Our Ref: PA/1039/sf  
Your Ref: S6/2010/1711/FP

3 September 2010

**Planning Application for Proposed Car Park on Land adjacent to The Viaduct, Hatfield Park**

Master Plan Drawing 843-VC-001B  
Site Plan Drawing 843-VC-002B

DRAWING NUMBER:
045-VC-002 B

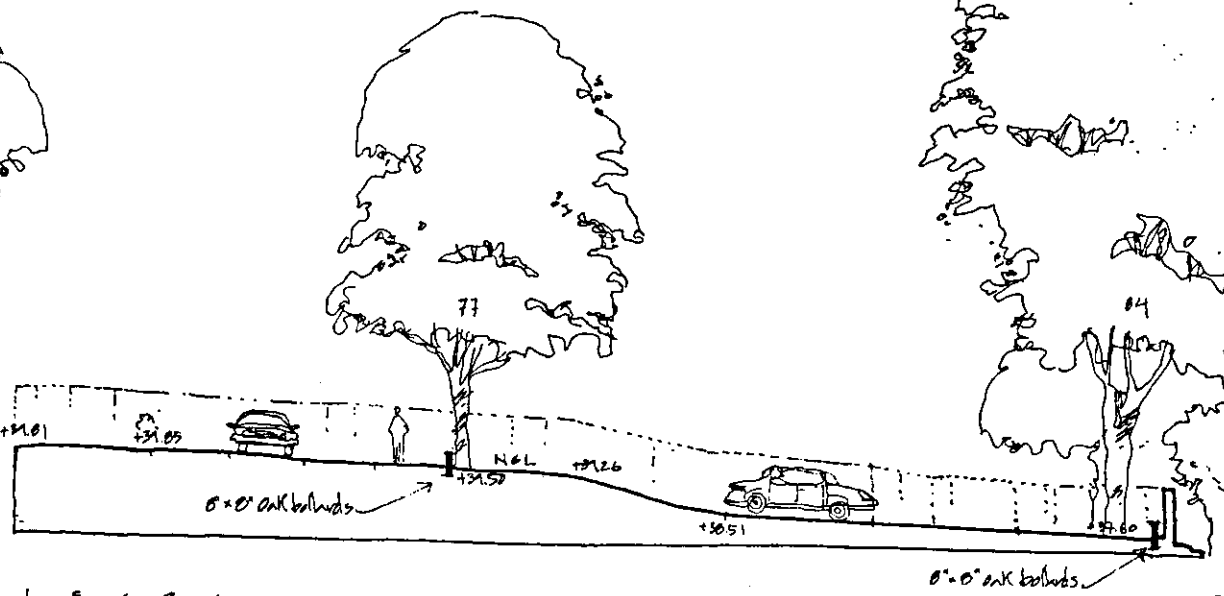
Having given full consideration to the comments and concerns raised by local residents in Park Close and elsewhere, we have amended the application by deleting the proposed additional parking area and access drive rear of the Estate cottages.
